CITY OF ALBUQUERQUE

Re: Bosque School Drainage Study Final Drainage Plan
Engineer's Stamp dated 12-4-12 (E12/D015)

Based upon the information provided in your submittal received 12-4-12, the above referenced study cannot be approved as the Drainage Master Plan (DMP) until the following comments are addressed:

SCHOOL DRAINAGE STUDY
COORS AND MONTANO

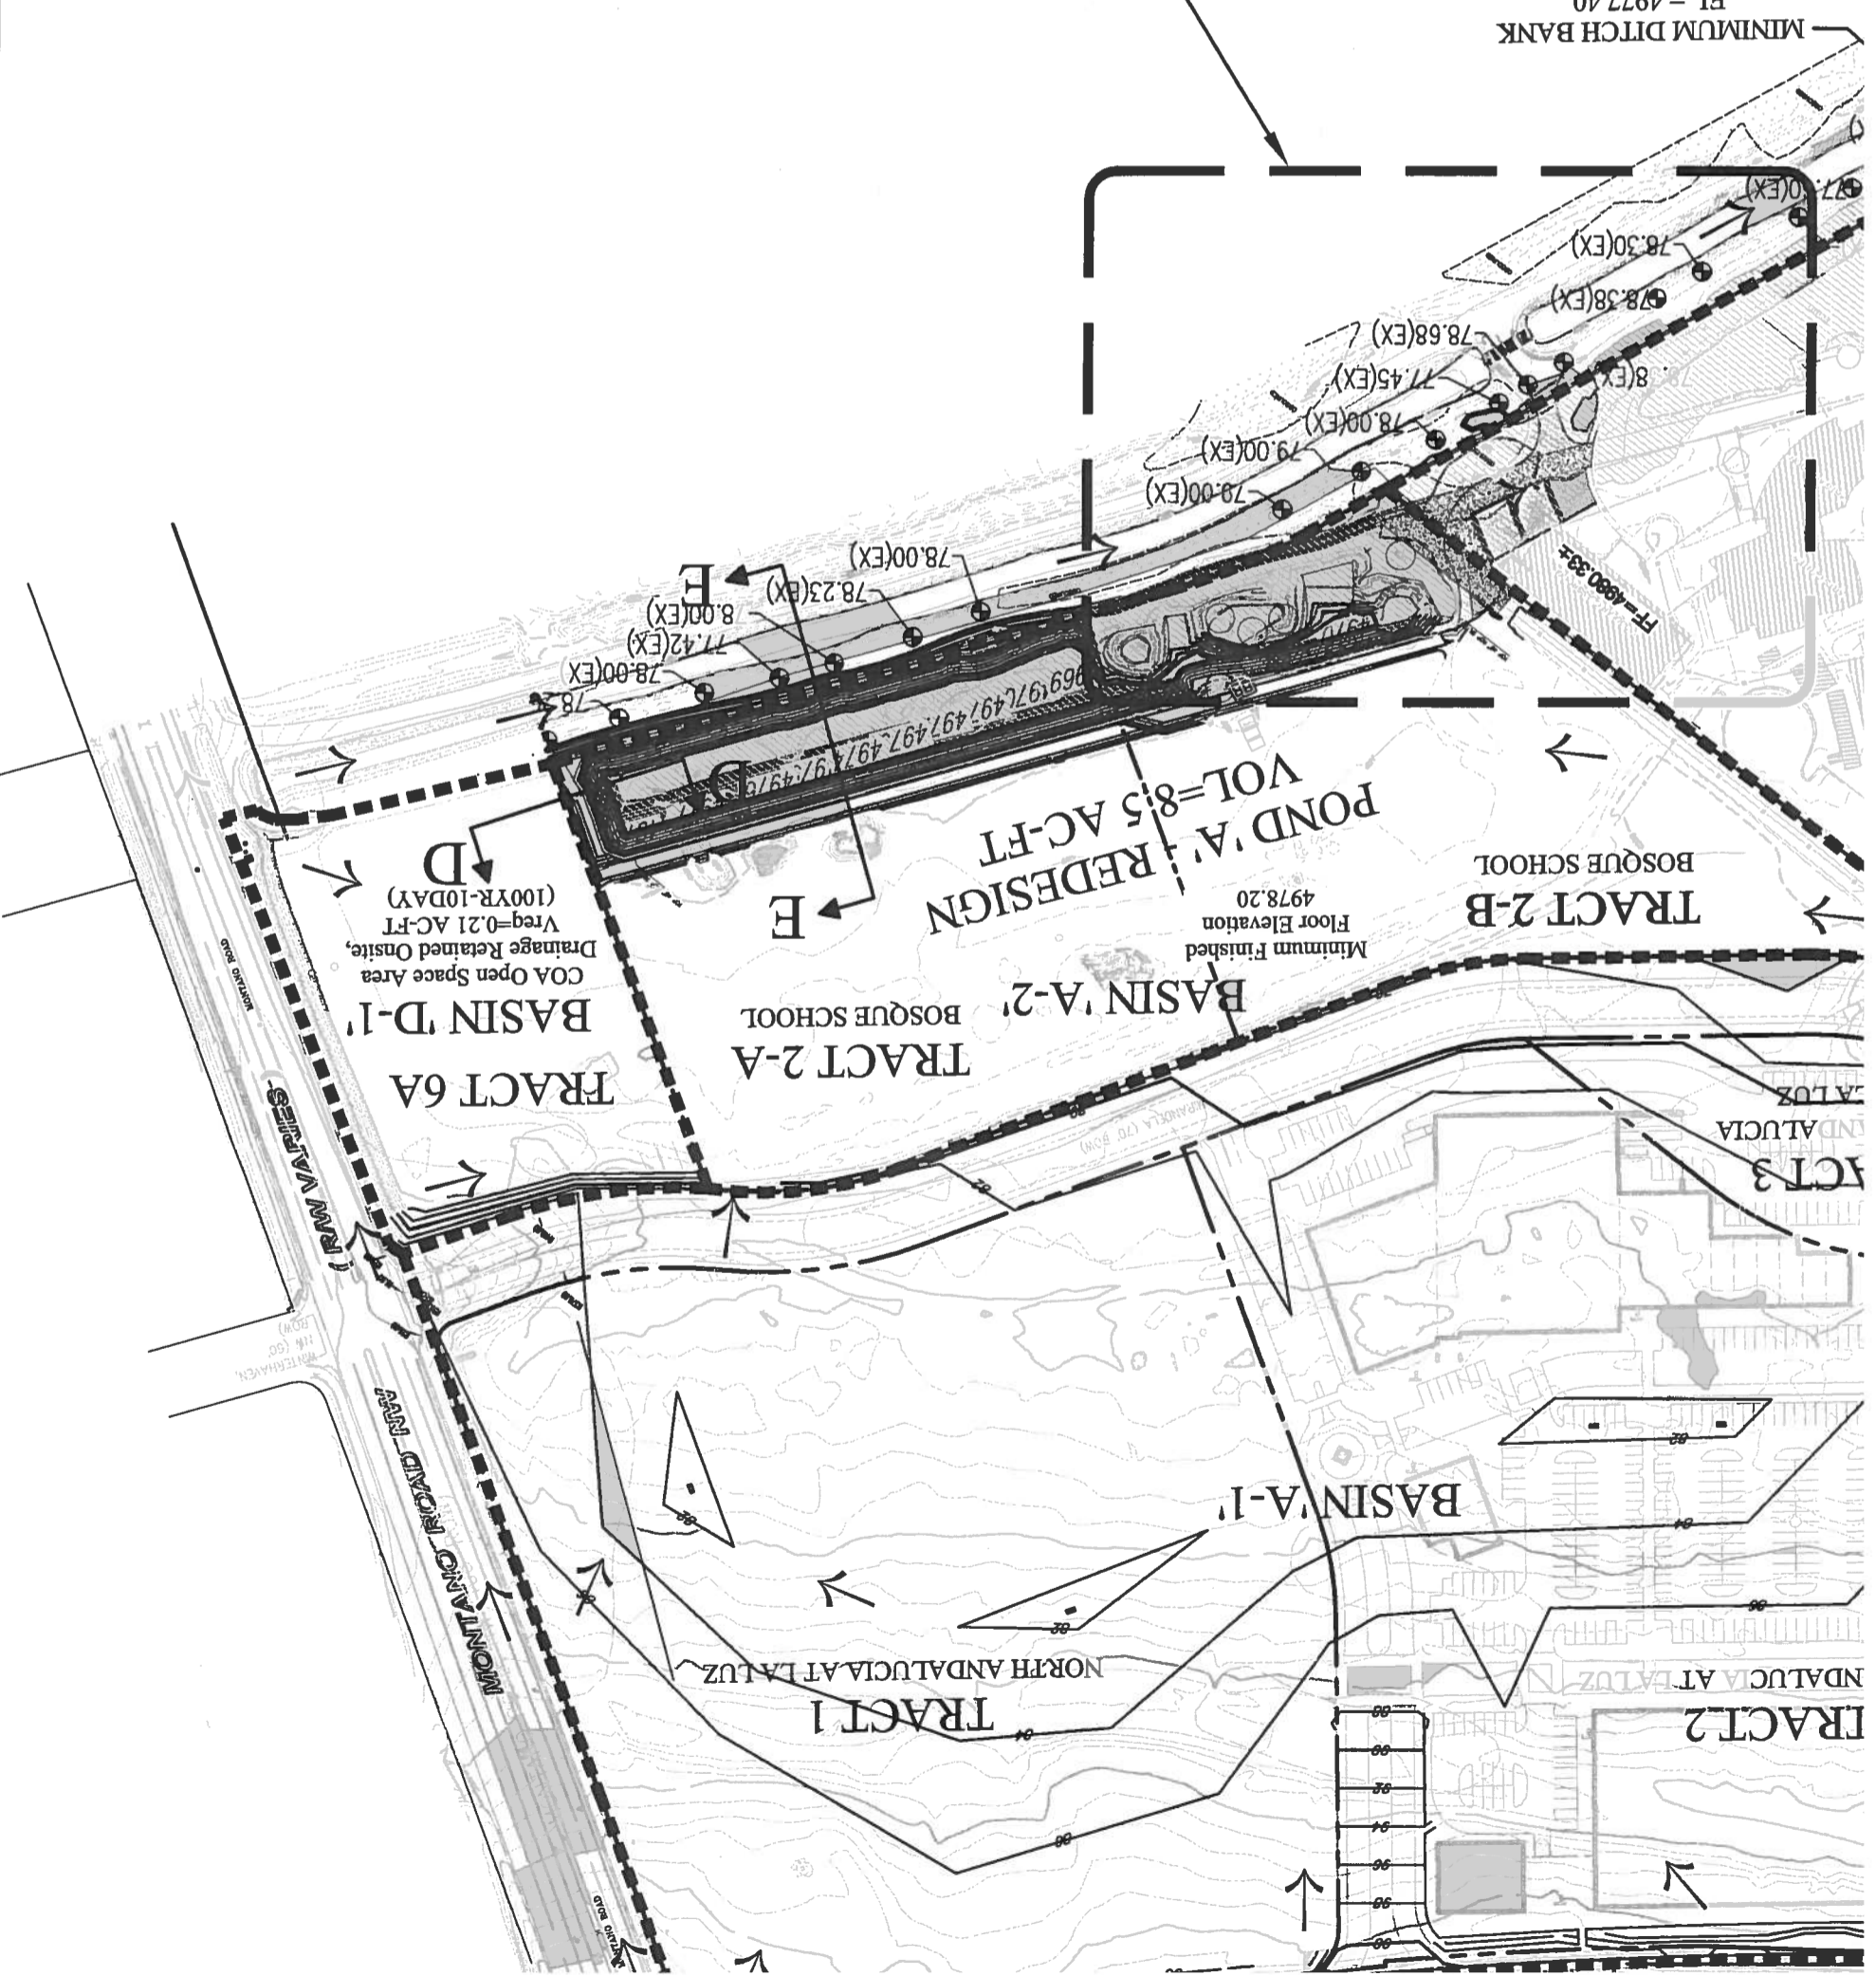
- Since the “flume” is not to be built across the MRGCD ditch, and grades appear favorable, Basin B-2 should drain to Pond B through Pond A, provided there is street and storm drain capacity. If there is inadequate street or storm drain capacity, a note should be added concerning the discharge limitation from this site. It is not clear, from the plan submitted, how well this basin will drain through the culvert and where it goes once it enters Basin B-3.

- Please add Basin A-5 to the “Spillway” paragraph.

- The plan proposes the spillway underneath the modular classroom building, which is not acceptable. Provide a section halfway between sections B-B and C-C.
- Should the retaining wall proposed in Section B-B, wrap around the building beginning at the 78 contour on the north side to a 77 contour on the south side? Access to the east door of the building has to be maintained.
- What do the “hatched” bands symbolize in Detail D? A build note would be appropriate.
